Development Facilitation Team (DFT) – Review Comments

DRB Project No: PR-2019-002411 Date: 5/08/2024 Agenda Item: #3 Zone Atlas Page: N-08

Request: MINOR AMENDMENT TO PRELIMINARY PLAT TO SHOW EASEMENT VACATION. PUBLIC SEWER EASEMENT VACATION TO BE REPLACED BY NEW EASEMENT. FINAL PLAT FOR UNIT 3.

Application For: SD-2024-00087 – Final Plat (DHO)

P.O. BOX 44414 RIO RANCHO, N.M. 87174
Phone (505) 896-3050 Fax (505) 891-0244 **Sheet 2 of 5**
cartesianbrian@gmail.com 200219

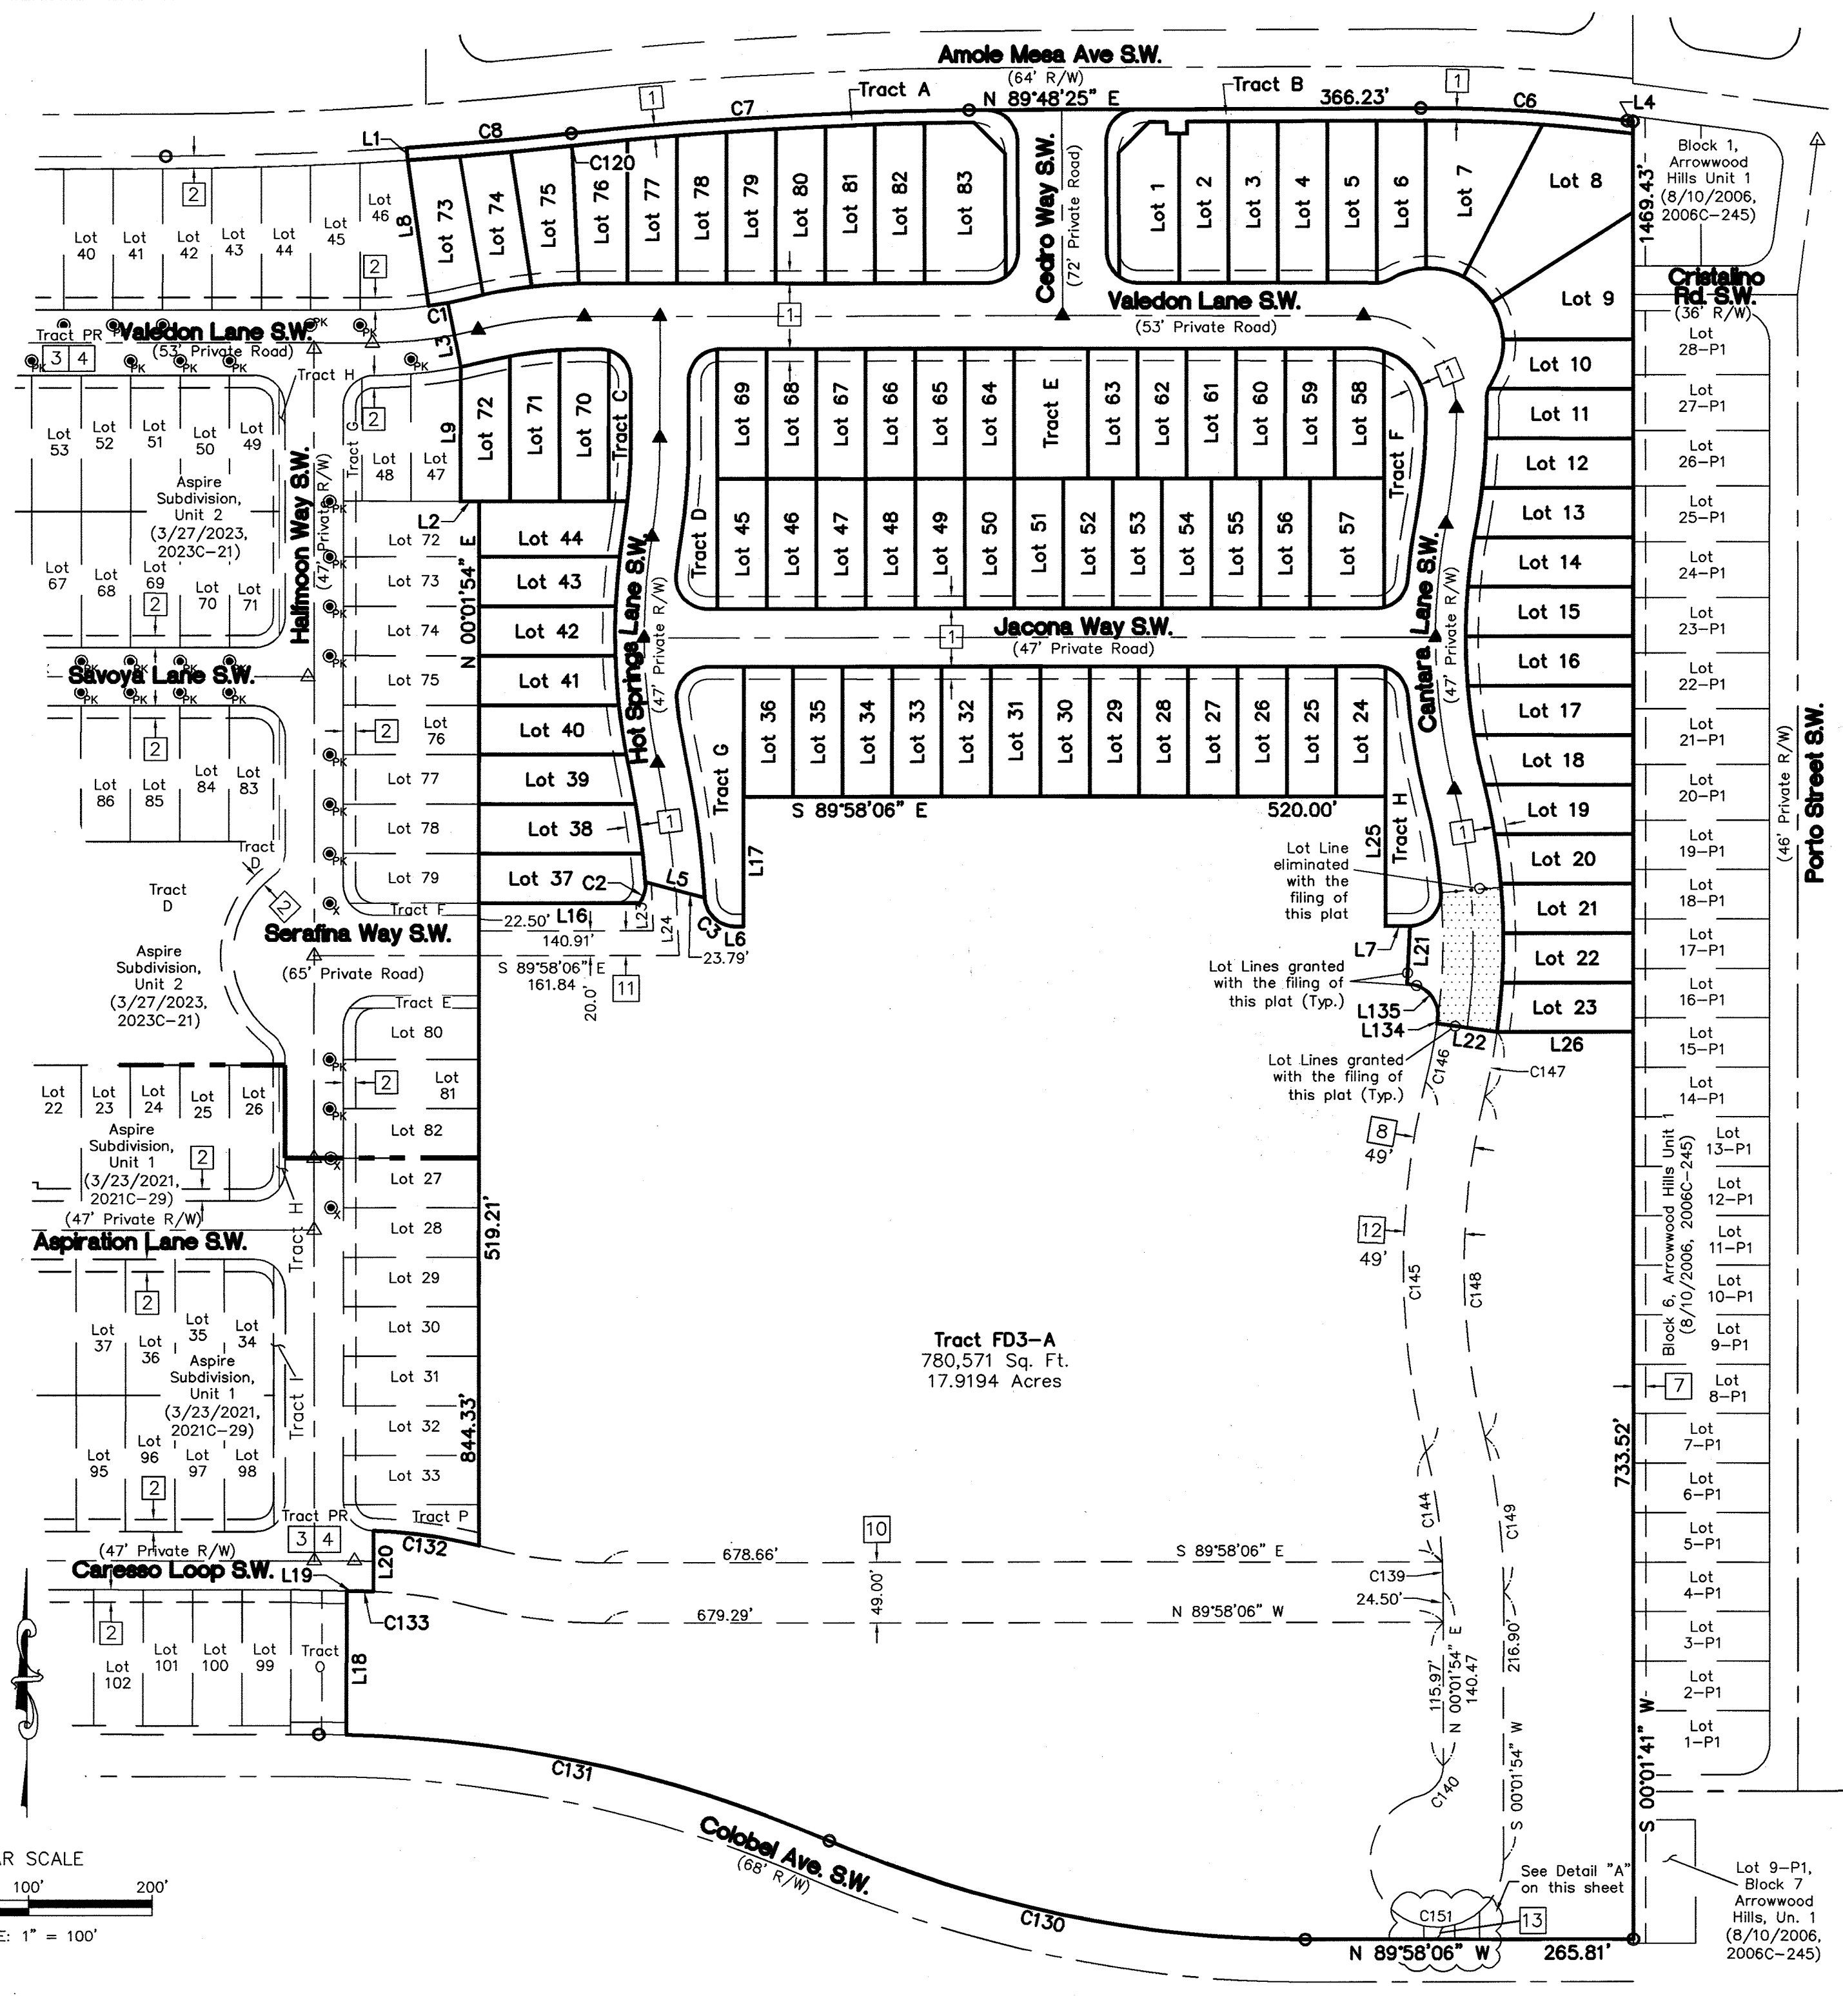
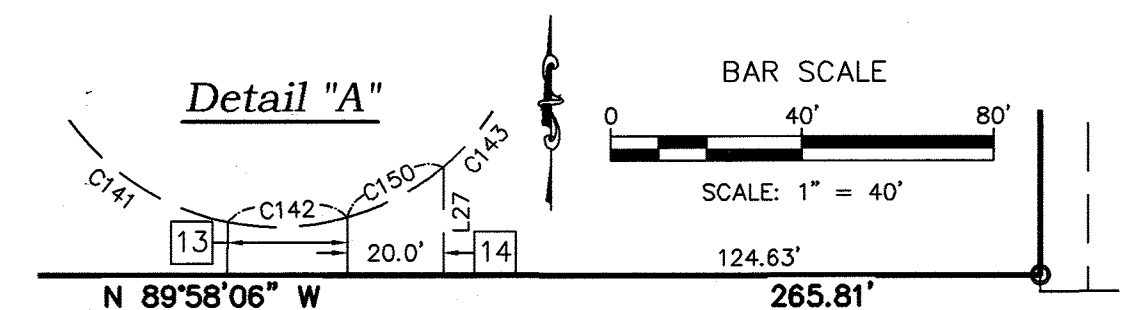
- Confirm if the Final plat request is for Unit 3, Unit 4, or both.
- Confirm for the DHO that this request is not introducing any further changes from the original DHO Preliminary/Final Plat approval aside from the easement that is going to be vacated and the public sewer easement being granted.

- The Project and Application numbers must be added to the Plat.
- AMAFCA Signature must be added to the Plat prior to final signoff.
- Per 6-6(L)(2)(d) 5 of the IDO, Final Plats shall include a list of any Vacations, Variances, Waivers, and deviations granted as an exhibit or note.

**Plat for
Aspire Subdivision Unit 3
Being Comprised of
Tracts FD2 and FD3
Aspire Subdivision, Unit 1
City of Albuquerque
Bernalillo County, New Mexico
March 2024**

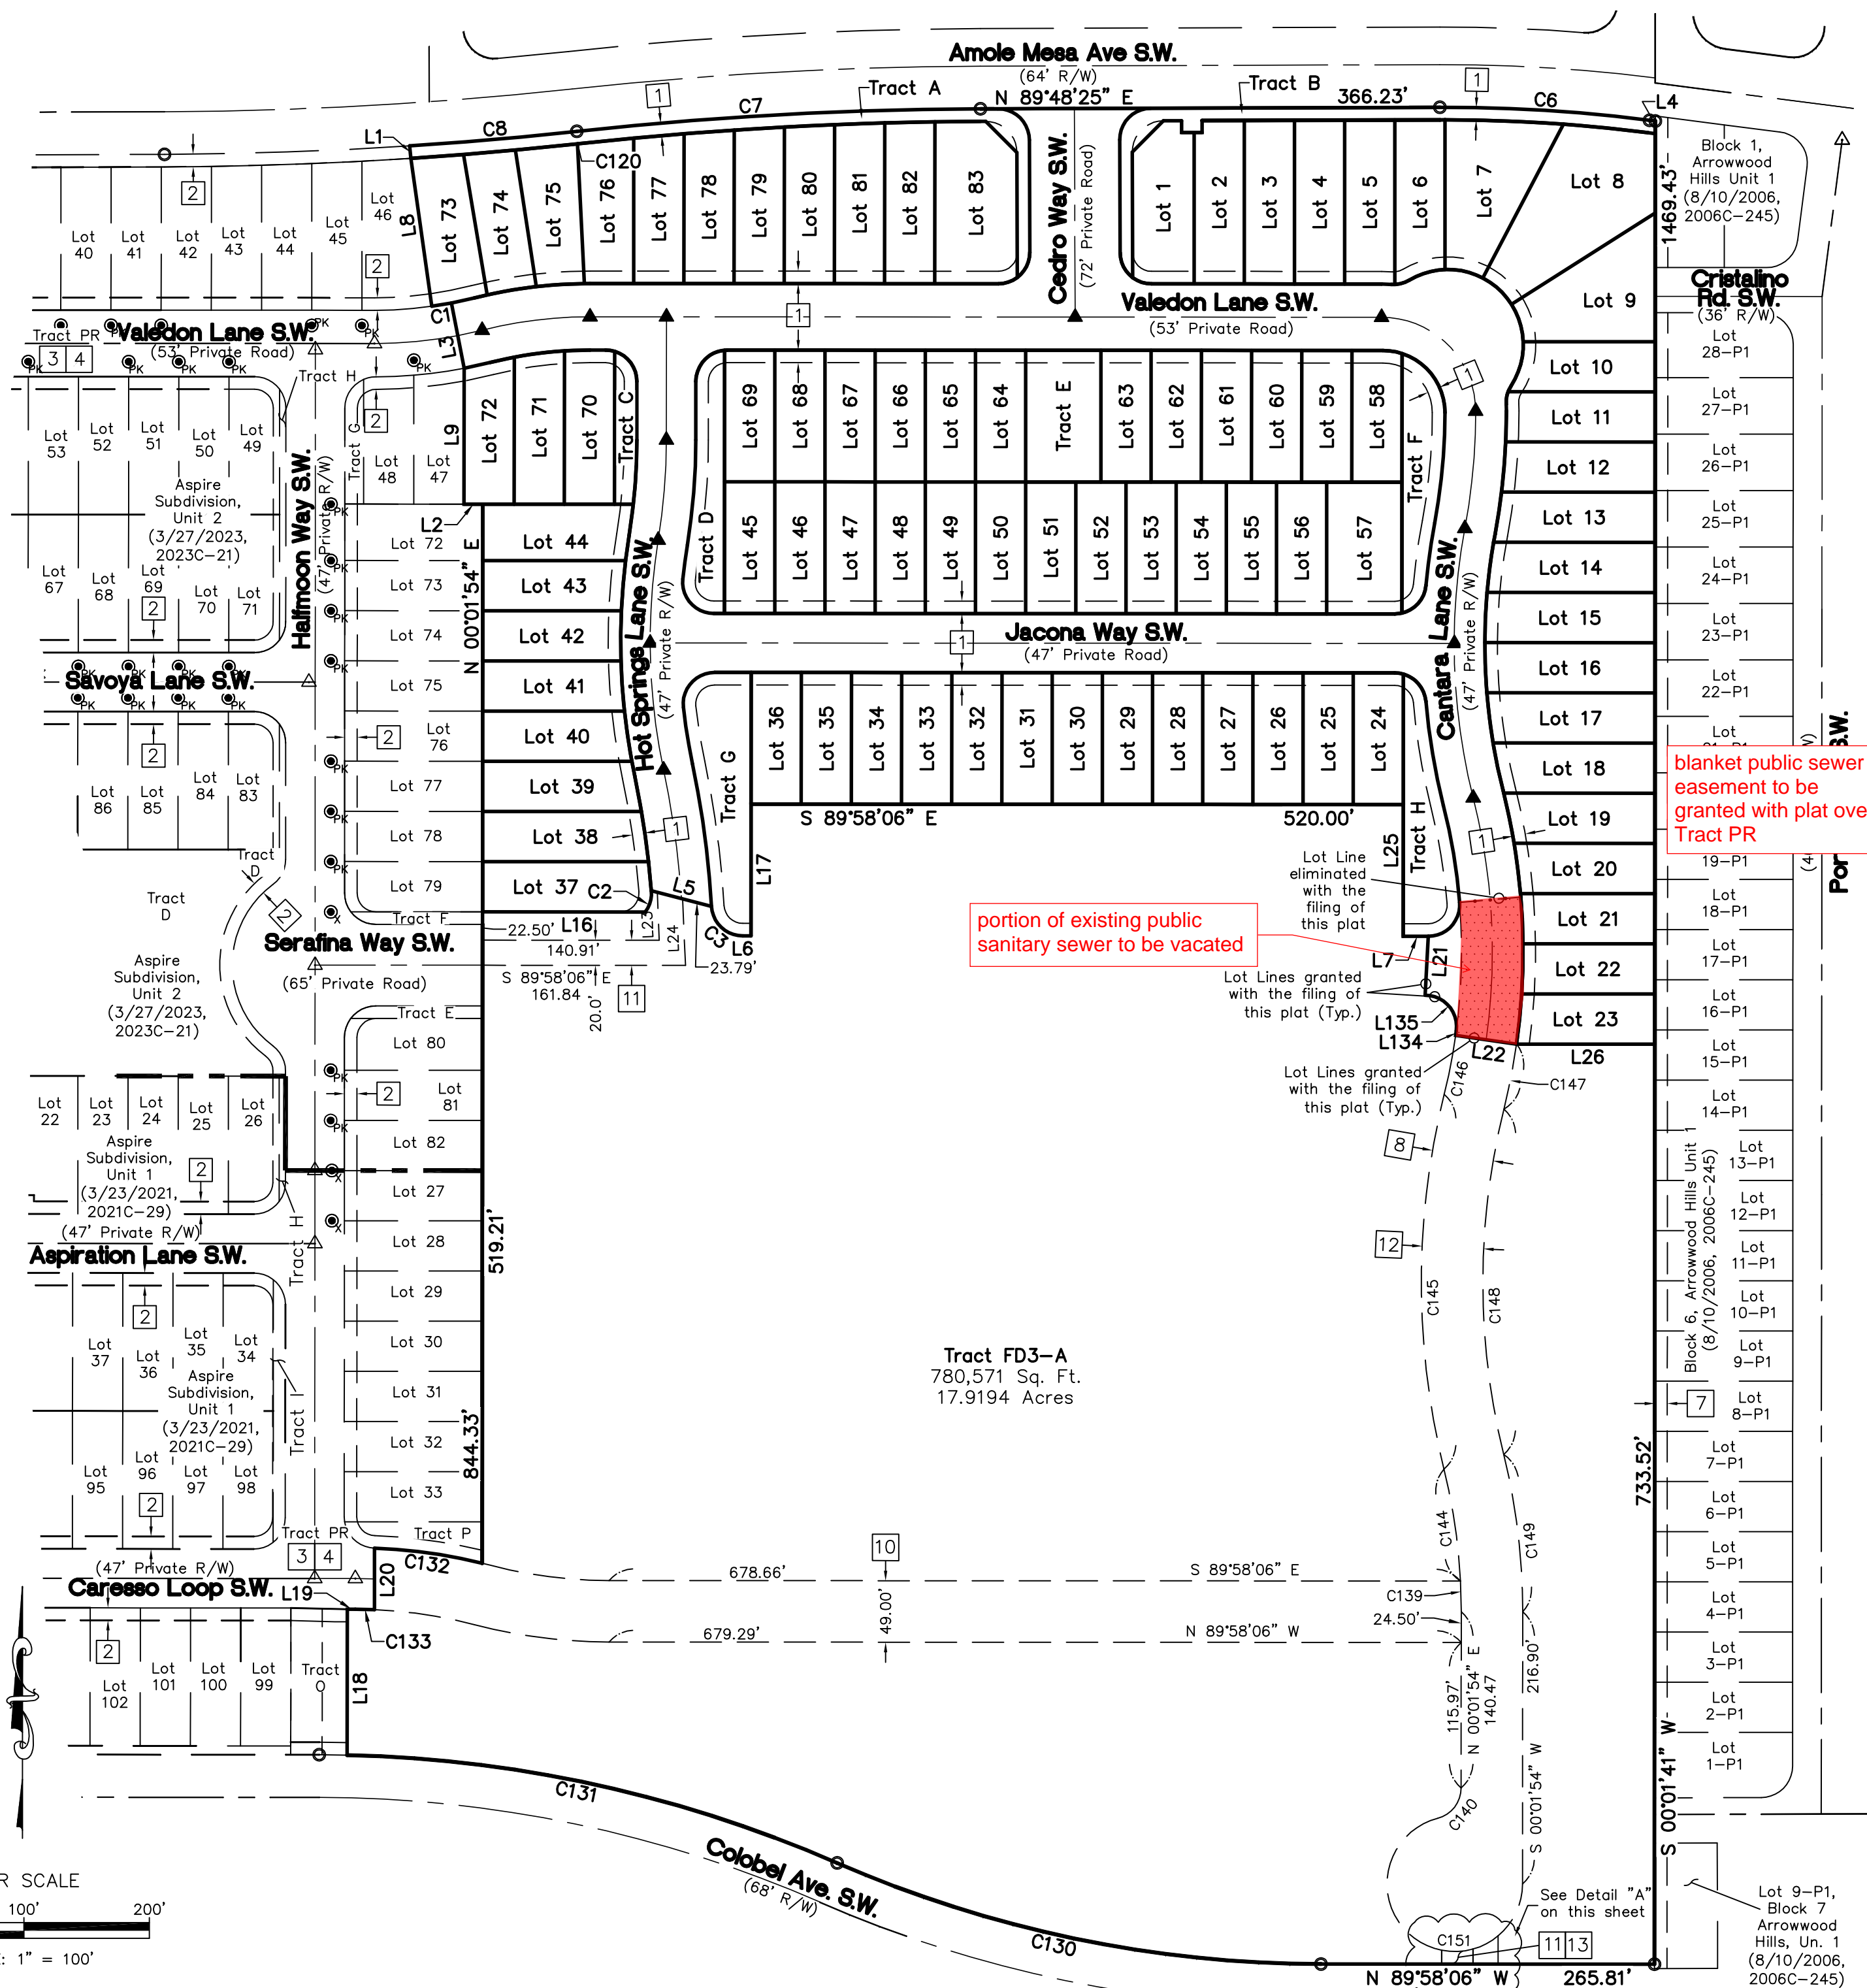
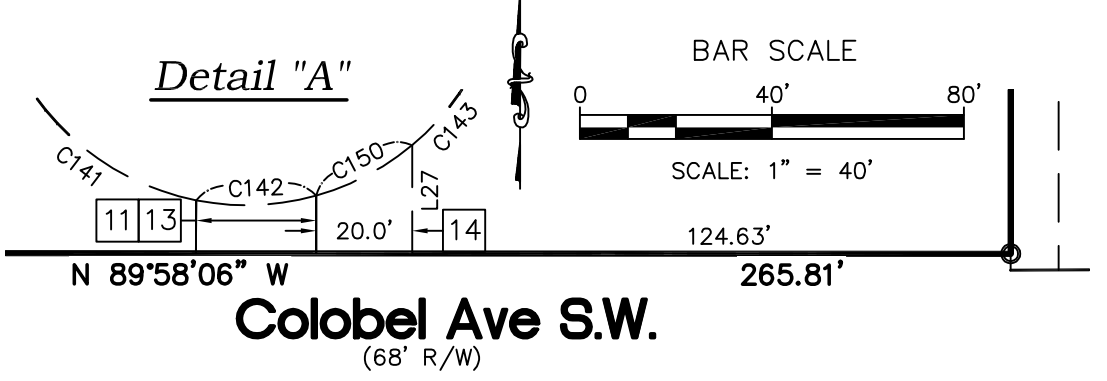
1. Easement note 10 needs to include public waterline as well.
2. Easement note 8 needs to also be identified for the portion being vacated for clarity.
3. Clearly identify dimensions for easements 10, 8, 11, and 13.
4. Provide a public waterline easement for the corridor along easement 8.
5. Identify Tract PR and add easement note 6 on the exhibit as well. See preliminary plat exhibit.
